Advice to the local planning authority

To LPA	Kirklees Council
LPA planning ref no	2026/62/90857/W
Our ref	26-0570
Site address	Pearl House (Former HSBC Bank), 2 Cloth Hall Street, Huddersfield, HD1 2EG
Proposal description	Conversion and extension of sixth floor plant room to form communal space, office and plant room area including re-cladding and new window openings, external alterations including new access door openings and replacement windows (in association with previously-approved change of use of floors 1-5 inclusive to 28 flats/studios and change of use of part of ground floor to provide associated facilities for the flats/studios, including refuse store, approved pursuant to application 2025/91221) (within a Conservation Area)
Date on fire statement	No dated (published on planning register at 19.05.2026)
Date consultation received	22/05/2026
Date response sent	11/06/2026

GROUND FLOOR PLAN

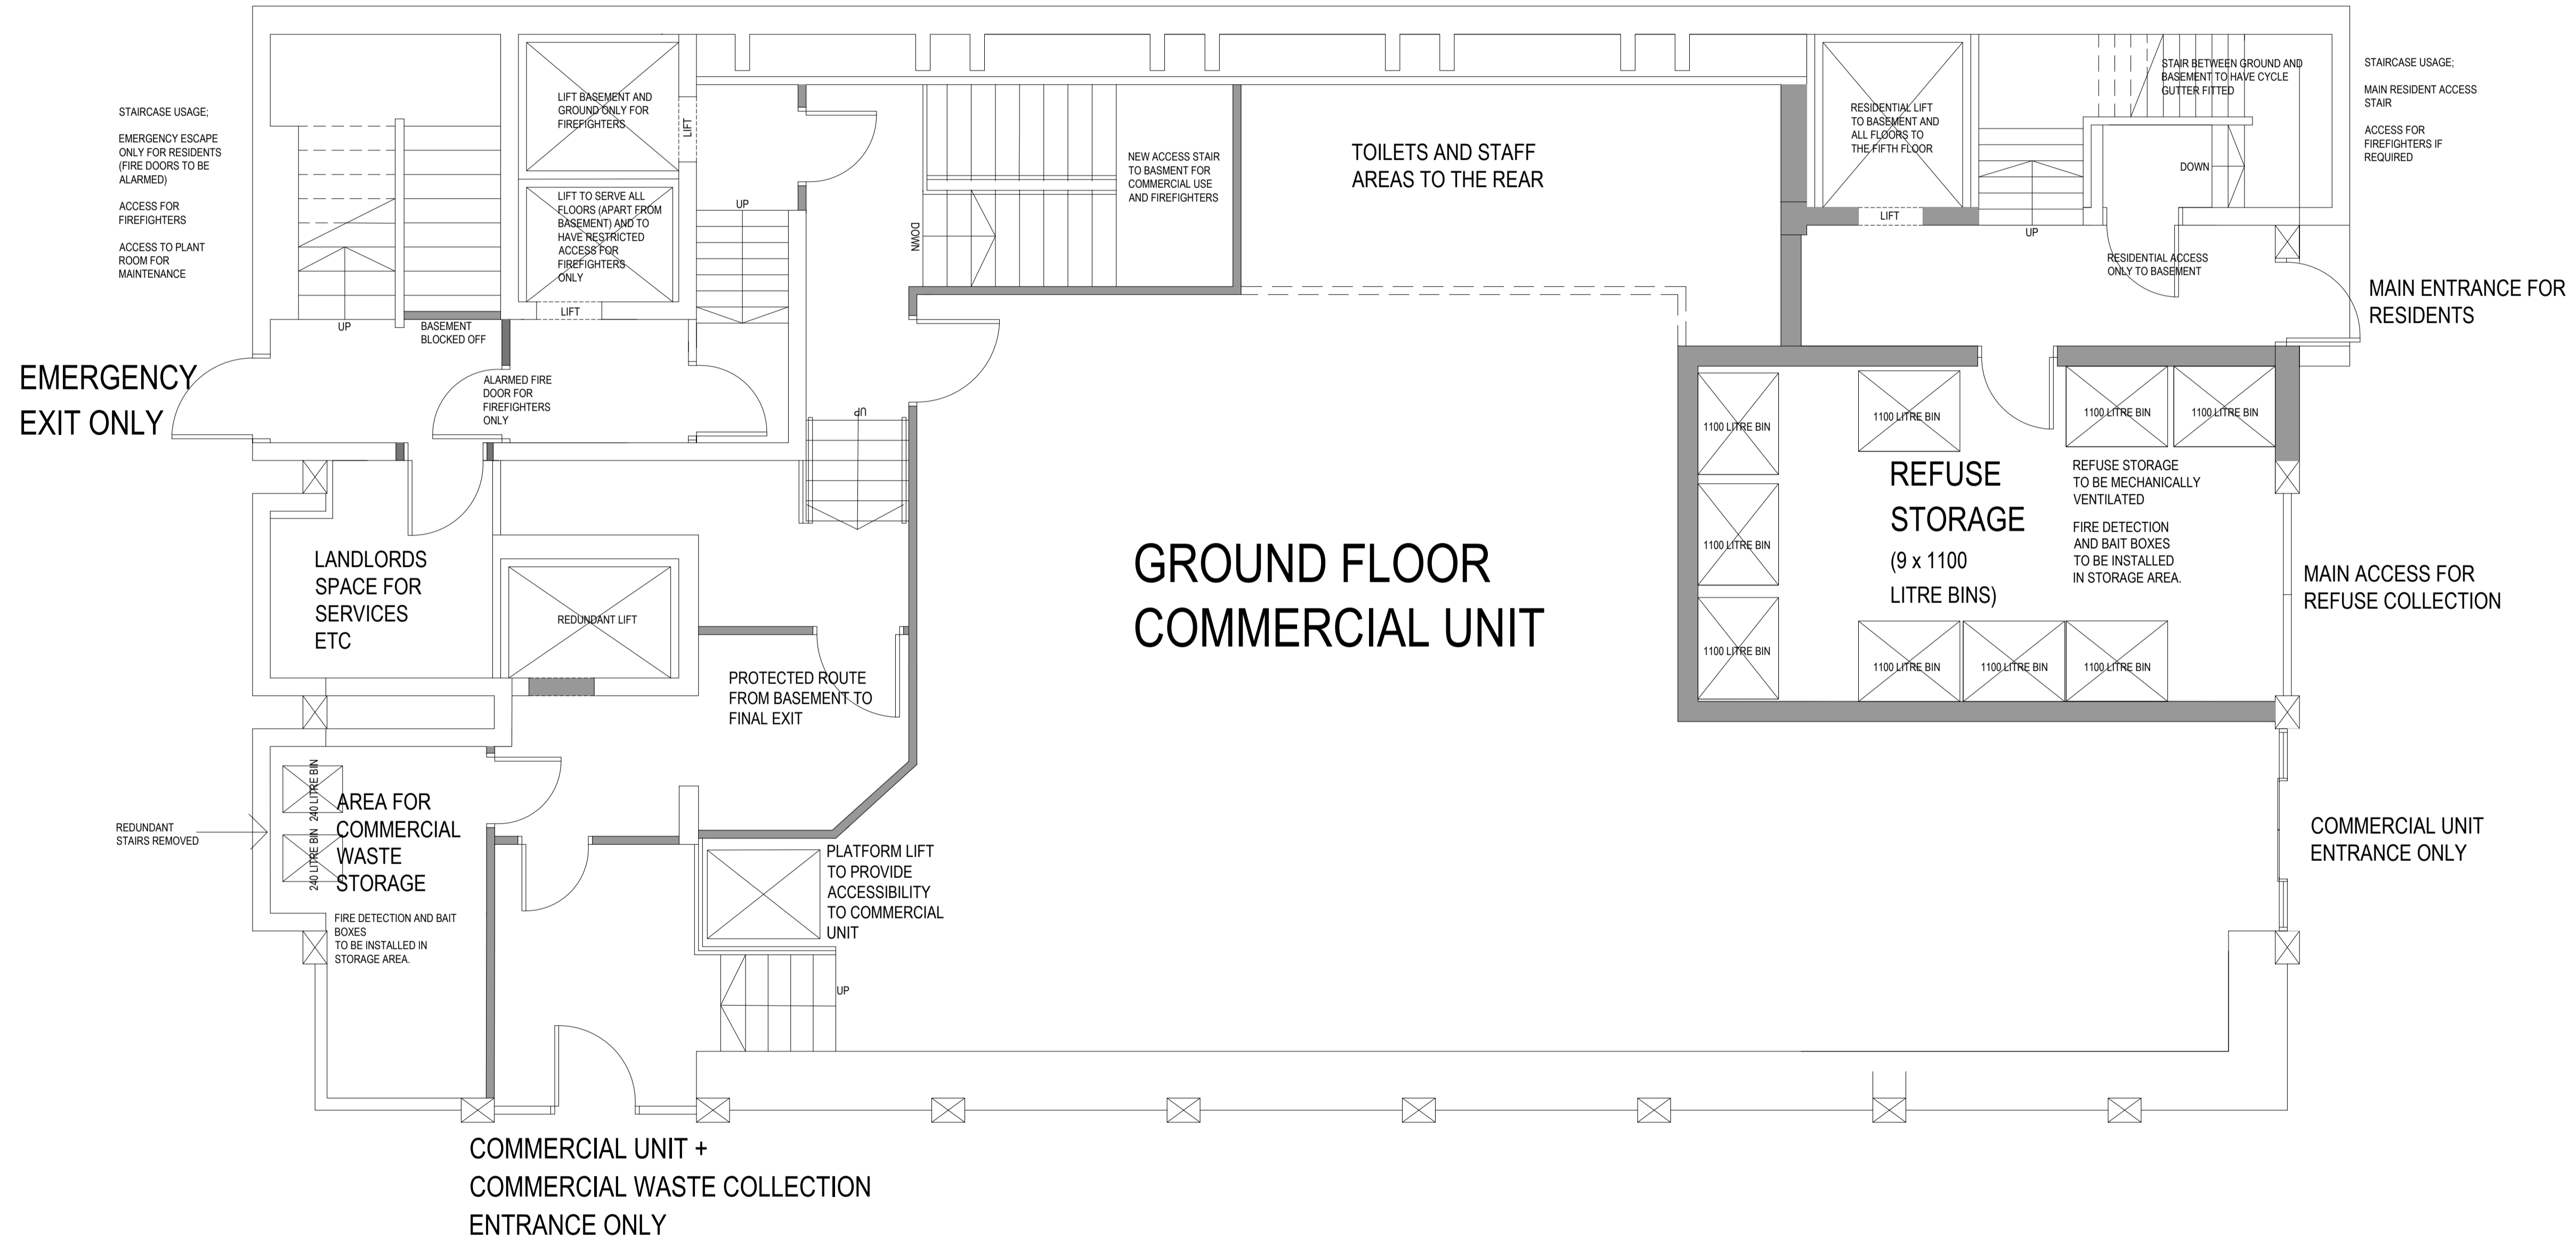
- 2.1 The proposed floor plans drawings (basement and ground floor) show that the 'Store for Ground Floor Commercial Unit' and the 'Ground Floor Commercial Unit,' communicate with the firefighting shaft which serves the residential area (flats on upper floors L1 to L5). Therefore, there is a connection between the residential and the commercial areas.

- 2.2 The adopted fire safety standard states that residential stairs in buildings of this height, should not serve other occupancies in. Accordingly, the residential areas should not communicate with the commercial areas.
- 2.3 Design changes to provide separation between these two different occupancies, in this instance, are unlikely to affect land use planning considerations, where they can be achieved by way of internal alterations. It will be for the applicant to demonstrate compliance at later regulatory stages.

- 2.4 The proposed Ground Floor Plan drawing shows a direct connection between the 'Landlords Space for Services etc.' and the firefighting shaft/firefighting stair enclosure.

- 2.5 The relevant fire safety standard recommends for the firefighting shaft/lobby, at the fire service access level, any access to it from the accommodation should be by way of protected lobbies (extract from BS9999:2017):

- 2.6 Also, from the information provided within the planning application, it is unclear if the 'Landlords Space for Services etc.' room has a commercial or residential use. It will be for the applicant to demonstrate compliance at later regulatory stages and seek advice from the LPA about the materiality of any design changes proposed if this would necessitate a new external entrance to serve the room.

- 2.7 The proposed Ground Floor Plan drawing shows that the residential 'Refuse Storage' connects directly with the stair enclosure which is the means of escape route for residential upper storeys.

- 2.8 According to the cited fire safety standard, any access to the escape route at the fire service access level, from ancillary accommodation, should be by way of protected lobbies.

- 2.9 Design changes necessary to comply, in this instance, are unlikely to affect land use planning considerations, where they can be achieved by way of internal alterations. It will be for the applicant to demonstrate compliance at later regulatory stages.
